INNER WEST COUNCIL SUBMISSION ON SYDNEY
METRO CITY & SOUTHWEST SYDENHAM TO
BANKSTOWN ENVIRONMENTAL IMPACT
STATEMENT

Figure 98: Marrickville Station – indicative layout of key design elements

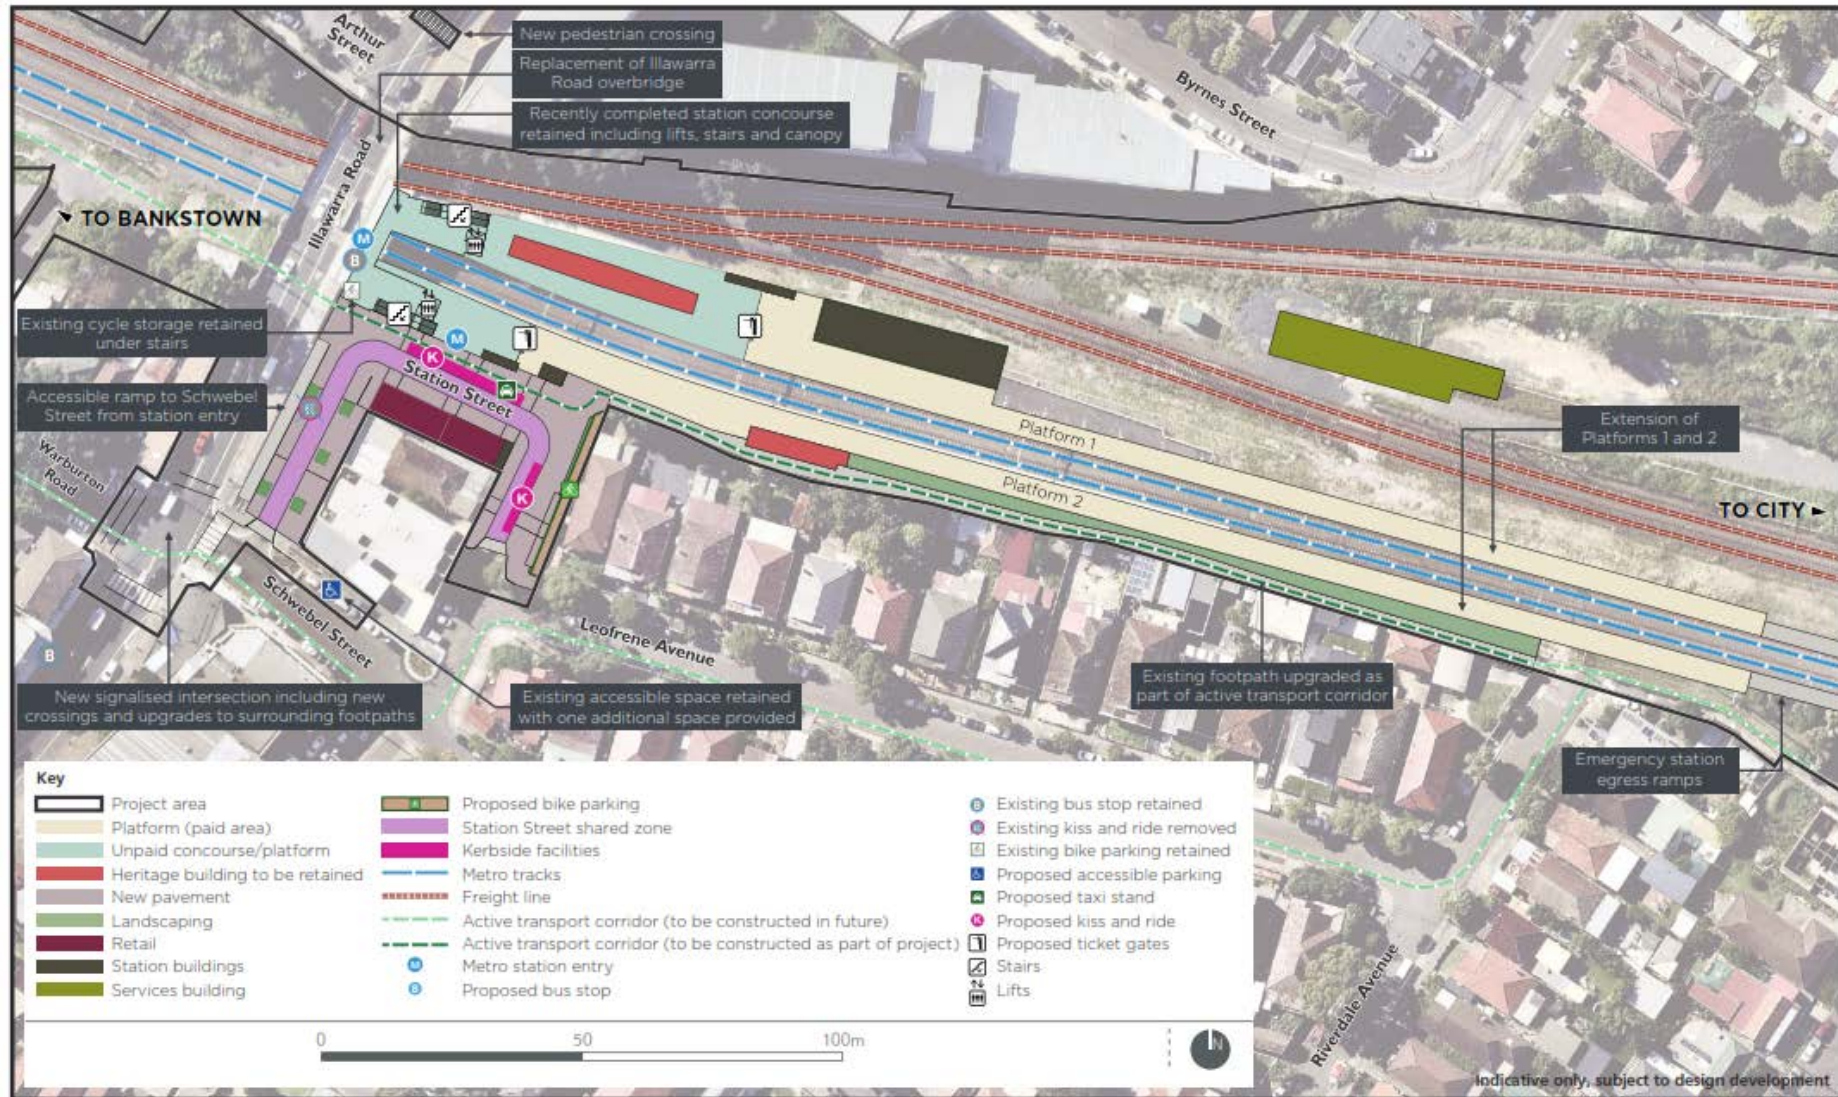
Marrickville Station

Whilst overall the improvements planned for Marrickville Station are welcome, concerns remain with regard to opportunities that are not being maximised:

The project continually outlines its importance as an enabler to growth along the corridor and it has clear objectives to increase the proportion of people travelling via public transport in the vicinity of the project. Thus it is disappointing to see the removal of an earlier proposed second entrance to Marrickville Station, at its eastern end at Victoria Road. This second entrance is also outlined in the Sydenham to Bankstown Urban Renewal Corridor Strategy. In the interests of supporting the proposed land use changes around Leofrene Avenue and Schwebel Street amongst others and encouraging a shift toward greater use of public transport, the creation of a second entrance to Marrickville Station is strongly recommended.

- It should be noted that the secondary entrance does not need to be substantial in size or stature but one that provides direct access to the platforms so as to reduce walking distances and increase the attractiveness of public transport. Given the high level of the tracks at this location, the entrance could be below the current track level rather than above as per most other project designs.

Whilst the minimal area of land to be acquired in Station Street will bring about an improved transport interchange, it will not create a plaza of any significance, as has been identified in the Sydenham to Bankstown Urban Renewal Corridor Strategy. The Strategy outlines that the entire block ideally be converted into a plaza in the interests of bringing about true transformation of the area (incorporating retail pods to ensure the required activation is achieved). This is imperative if increased building scale is to occur around the plaza, as is identified in the Strategy. It is thus recommended that the project take on this responsibility, acquiring the entire block and enabling the development of the plaza, in the interests of achieving alignment between the project and the Strategy given the role of the project as an enabler for growth.

The proposed signalisation of the Illawarra/Schwebel/Warburton intersection is also supported. It should be noted that Council previously conducted a study into providing signals at this intersection and found that maintaining the existing mid-block signals on the crest of the Illawarra Road Bridge works more efficiently than replacing these signals with a marked foot crossing. Thus the retention of the existing signalised crossing on the crest of the bridge is recommended in addition to the installation of new signals at the Illawarra/Schwebel/Warburton intersection.

It should also be noted that the proposed location of the new pedestrian crossing on Illawarra Road at Arthur Street is likely to be too close to the crest of the bridge and as such may not meet relevant standards with regard to sight lines. The project must be required to model these proposed changes to ensure that network efficiency is maintained whilst ensuring that pedestrian safety is enhanced.

The area around Marrickville Station is lacking in trees; any tree removals will have a significant impact on the existing sense of place. Existing trees must be retained and protected. Any tree removal must be replaced with advanced specimens of the same size.

With regard to the proposed replacement of the Illawarra Road Bridge, currently there is a cycle route along the Illawarra Road Bridge but the width of the bridge is too narrow at present to cater for both a bus stop and cycle route and as such the bridge becomes a pinch point for cyclists. In order to provide a safer cycle route and safer access to the bicycle parking at the station, the bridge will need to be widened as it is replaced. It is thus strongly recommended that the new Illawarra Road Bridge be built so that it is sufficiently wide enough to facilitate north-south separated bicycle connections along Illawarra Road.

Regarding the proposed replacement of the Albermarle Street Bridge, this bridge should be widened as part of the project to include a 2m wide footpath on either side of the bridge. Traffic lanes should also be widened sufficiently to 3.5m in each direction.

- The existing cycle route along the rail corridor between Station Street and Victoria Road/Myrtle Street is a direct segment of Council's regional bicycle route. Rerouting of this cycle route provides a more circuitous route from the station to Myrtle Street, does not comply with user hierarchy intent, and would be a downgrade from the connectivity that exists at present; it is therefore not recommended. The project suggests enhancement of the existing footpath, which is supported, but it is recommended that the cycle route be incorporated in this section rather than taking an on-road route.

- There may also be opportunity to widen this path by minimising the landscape area between the Platform 2 and the path or use of vertical landscape elements as part of fence elements for space efficiency – while still maintaining visual surveillance for safety.

- Whilst the newly proposed active transport connection under the newly constructed Illawarra Road Bridge is acknowledged, it should be noted that the main east-west cycle route would thus not travel via Warburton Road (as shown in the Marrickville Station layout).

Figure 100: Dulwich Hill Station – indicative layout of key design elements

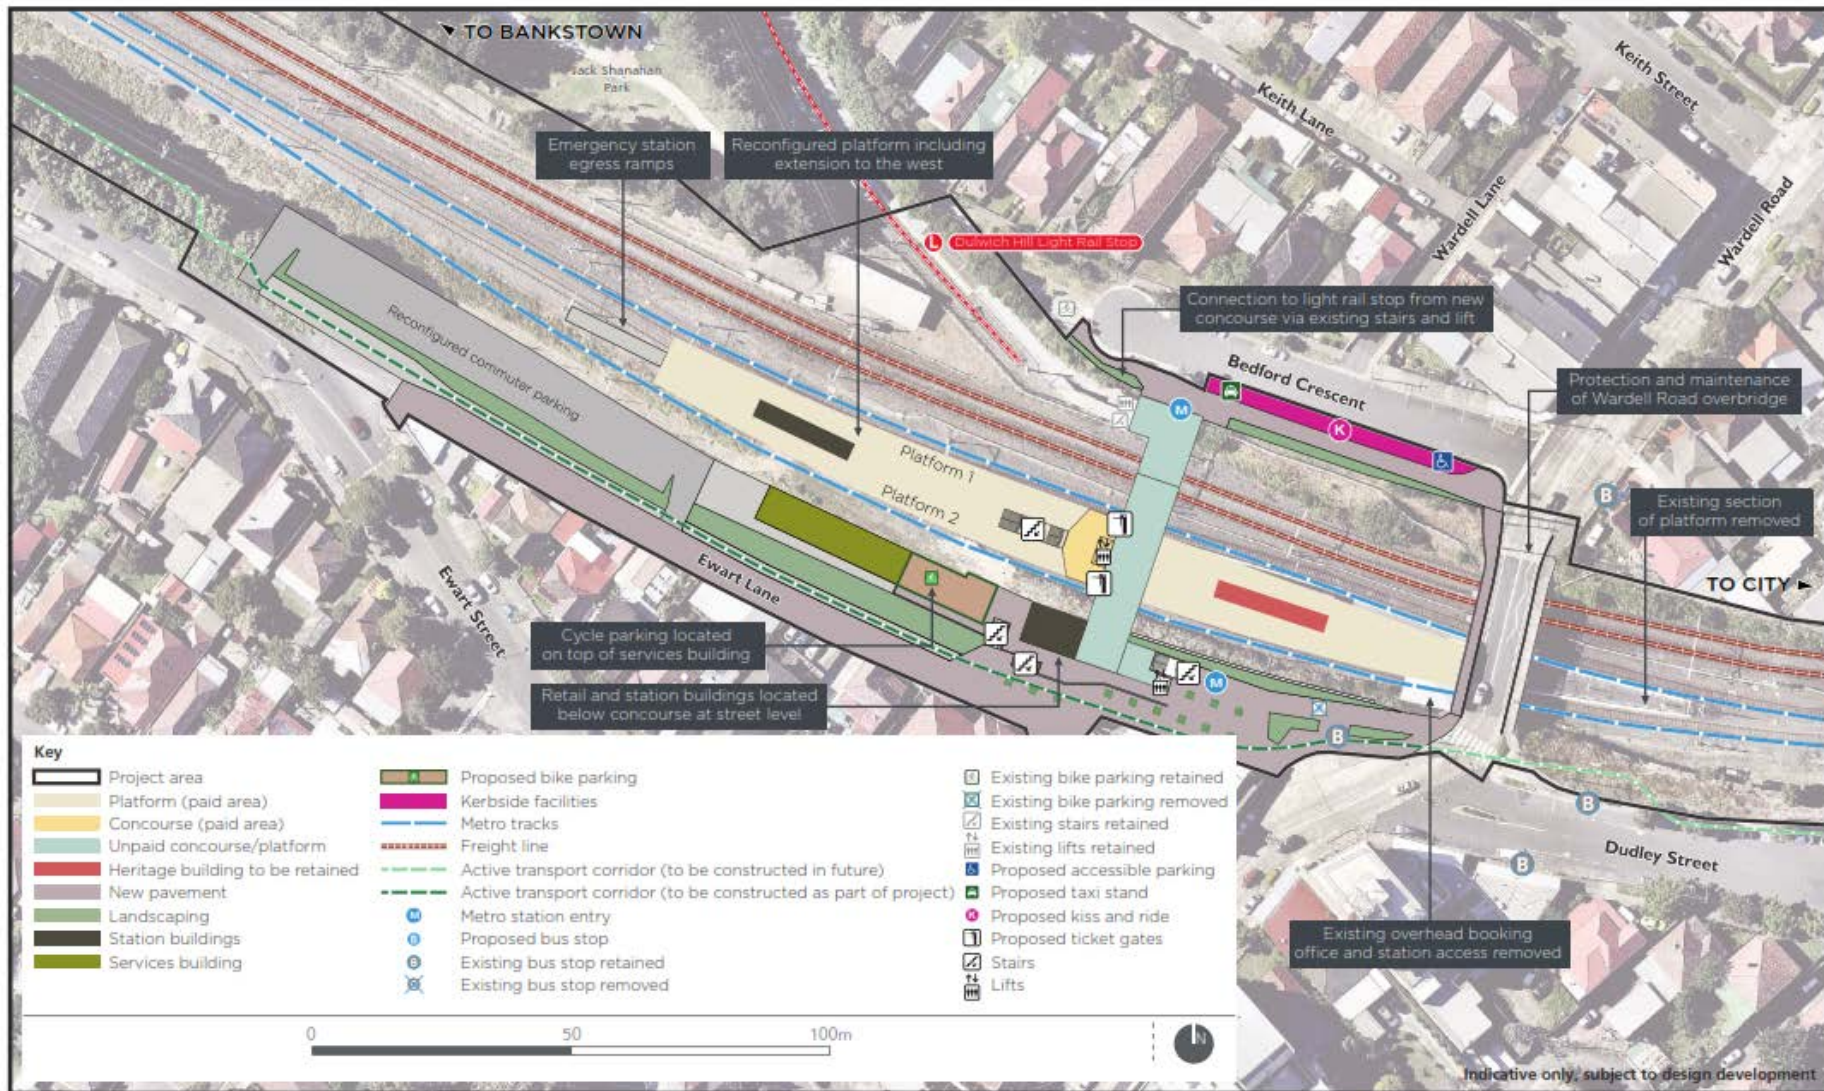
Dulwich Hill Station

Consistent with the heritage objectives of the project and the design guidelines that aim to retain the unique character of the existing place, the existing overhead booking office must be retained and repurposed. Given that there is only limited retail activation fronting the new plaza (to the front of the proposed new station entrance), consideration of repurposing the booking office could complement significantly to its (retail) activation.

The scope should include new signalisation of the Wardell/Dudley intersection (to the south of the railway bridge) to facilitate improved pedestrian crossing, including direct pedestrian crossing routes from both the north and south sides of Dudley Street to the new station entrance plaza as well as that across the entrance of Dudley Street; this would provide the safest, highest amenity option, given the awkward configuration and challenging grades at this location. This would also provide safe pedestrian connection between Metro/Light Rail and bus interchange.

Seamless integration of the upper and lower plaza areas on the south side of the station must be achieved with regard to the following:

- Dropping levels to Ewart Lane and stair connections in a constricted area
- Creation of the best design solution to meet the identified activity levels
- Allowing for easy movement of all users
- Maximising safety, being cognisant of the new station entrance no longer directly fronting onto Wardell Road
- Accommodation of pedestrian and cycle movements around the plaza and concourse areas

Further, the design of the western stairs and interaction with retail activity under the concourse may cause congested circulation – circulation could be enhanced by pushing back the retail front from the concourse overhang to create a greater circulation area.

Footpaths must be provided on both sides of Ewart Lane (as per Council's draft public domain master plan for the Dulwich Hill Station Centre), given the anticipated numbers of pedestrian existing the station and the substantial development that could occur in the adjacent block between Ewart Street and Ewart Lane as a result of the changes proposed in the Sydenham to Bankstown Urban Renewal Corridor Strategy.

The footpath on the western side of Wardell Road across the railway bridge should be widened, given the existing narrow width and the anticipated additional numbers of pedestrians in the vicinity of the new station entrance. This is the sole opportunity to create such an improvement and not addressing this issue would be inconsistent with the project design guidelines regarding enhanced customer circulation, customer safety, accessibility, connectivity (specifically mentioning cross-corridor connectivity) and pedestrian movement.

The reconfigured commuter car parking area appears to now cover an existing area of significant trees, which is not supported and must be redesigned.

The bus stop proposed to be retained (outside of the new plaza) on Wardell Road is unnecessary and should be removed – bus stops are to remain in Dudley Street in both directions.
